2010/1455 High Bank

I respond to the comments of the Highway Officer. The Inspector's findings are contained in points 10, 11, 13 & 14:

10.5 Critical dimensions of parking stalls with stall size of 5.5x

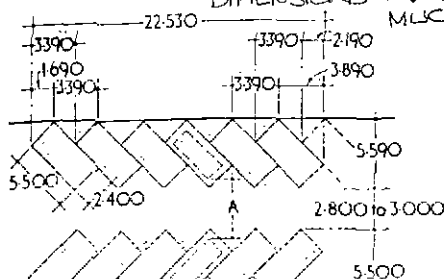
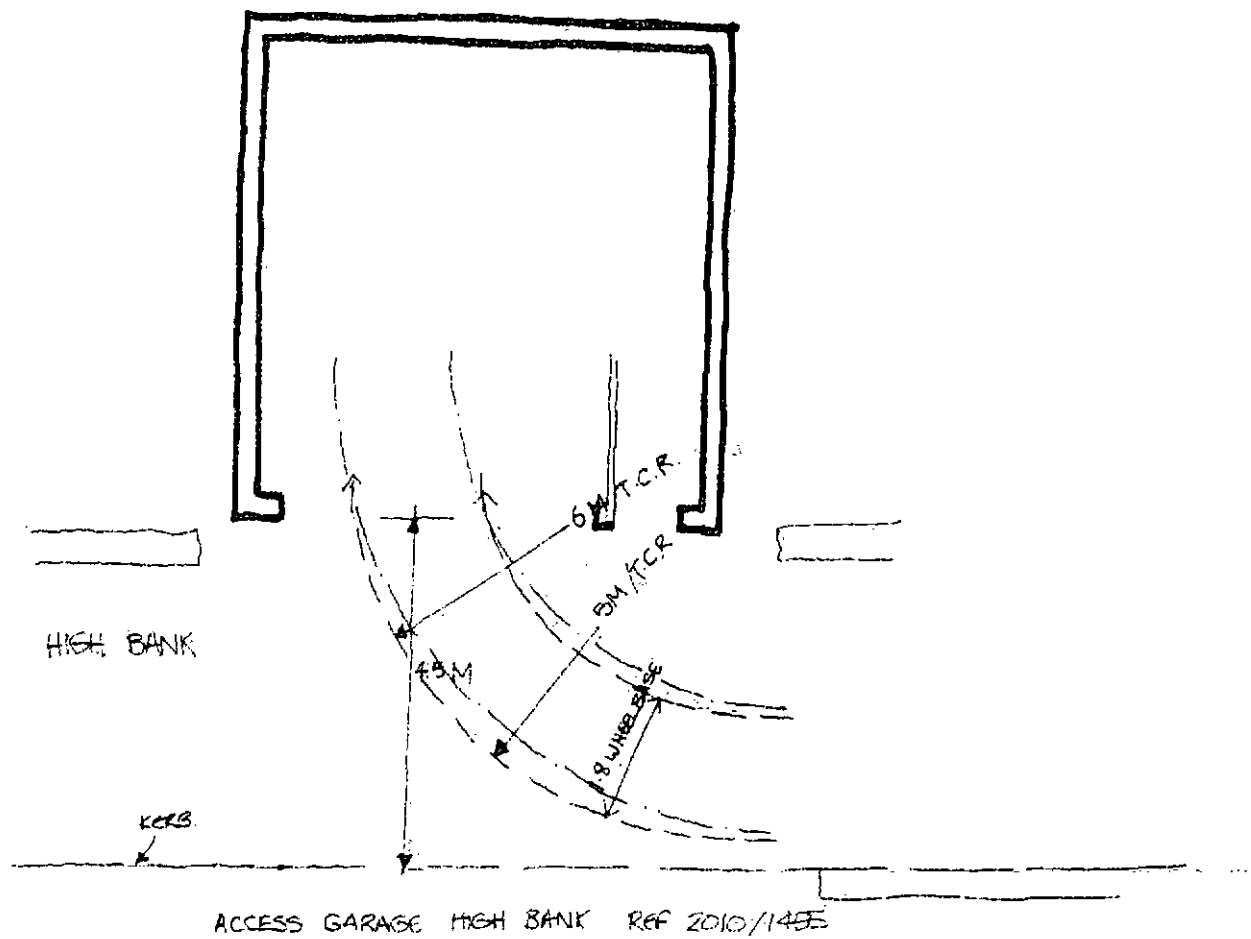
In summary, the garage access is better and more workable than the already approved unit to the east. I doubt if a drawing was required to deal with the highway issues then but I enclose the required plan.

PLAN ELEVATIONS SITE PLAN 1900

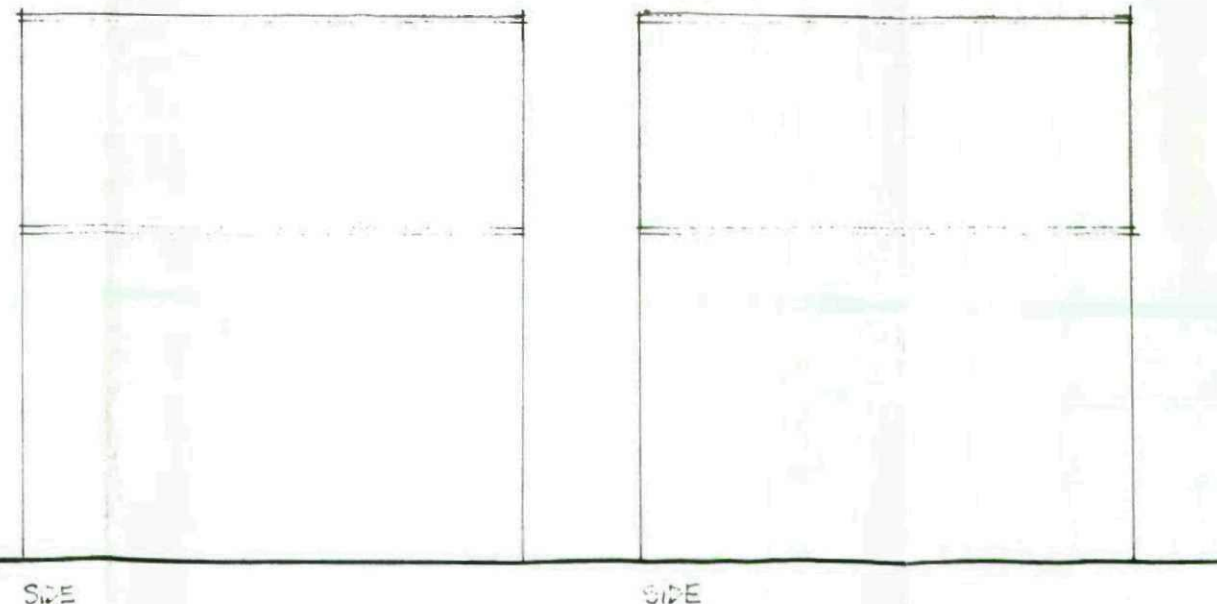
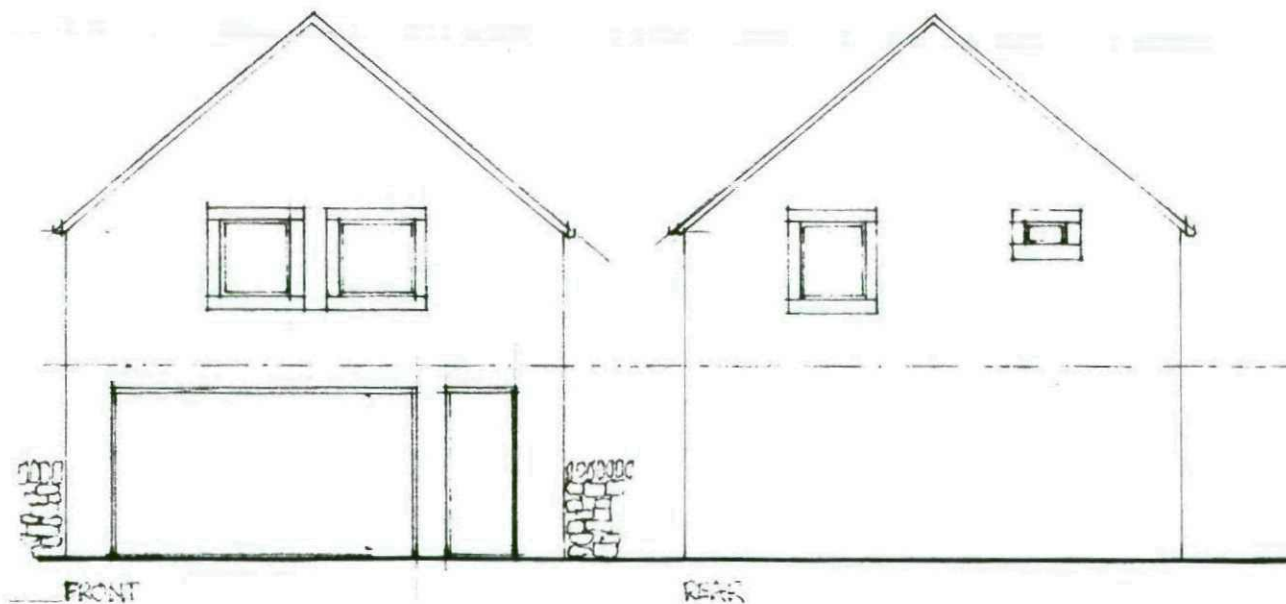
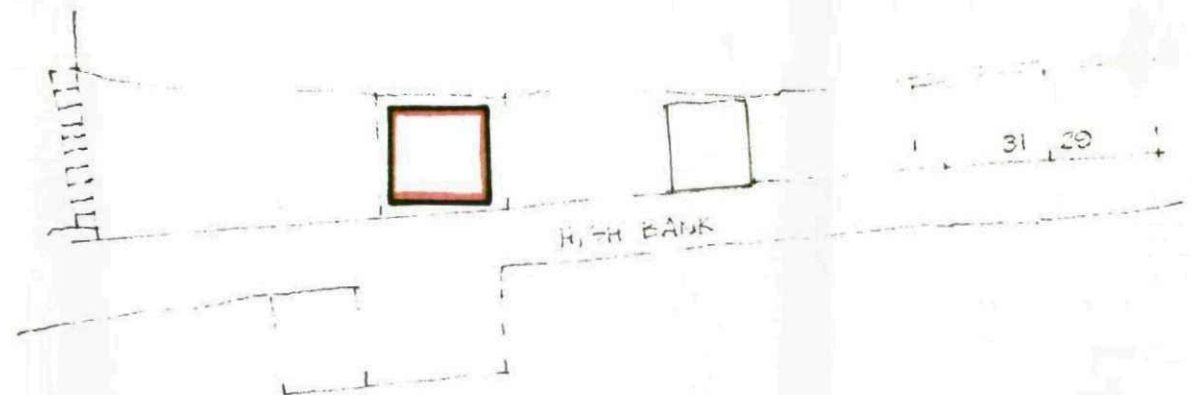
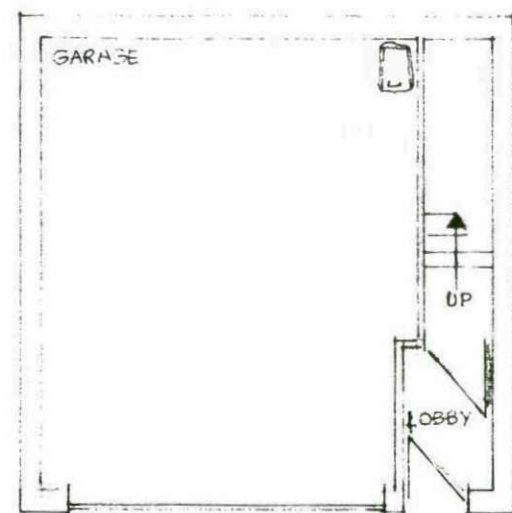
10. The new garage door now at 4 metres wide is the same as the newly built garage to the east. There is no need to use any area of land beyond the carriageway to access our current proposal. The Inspector regarded the existing garage as adequate, which it is, as presumably it was approved under both planning and highways and causes no conflict or difficulty in use. Further my proposal is set back 0.5 metres into the site. At the entry point the effective carriageway (High Bank) is 4.5 metres wide. This is actually 800 mm wider than the existing road in front of the garage to the east. Many modern estate housing access ways are this width giving access to drives and garages.
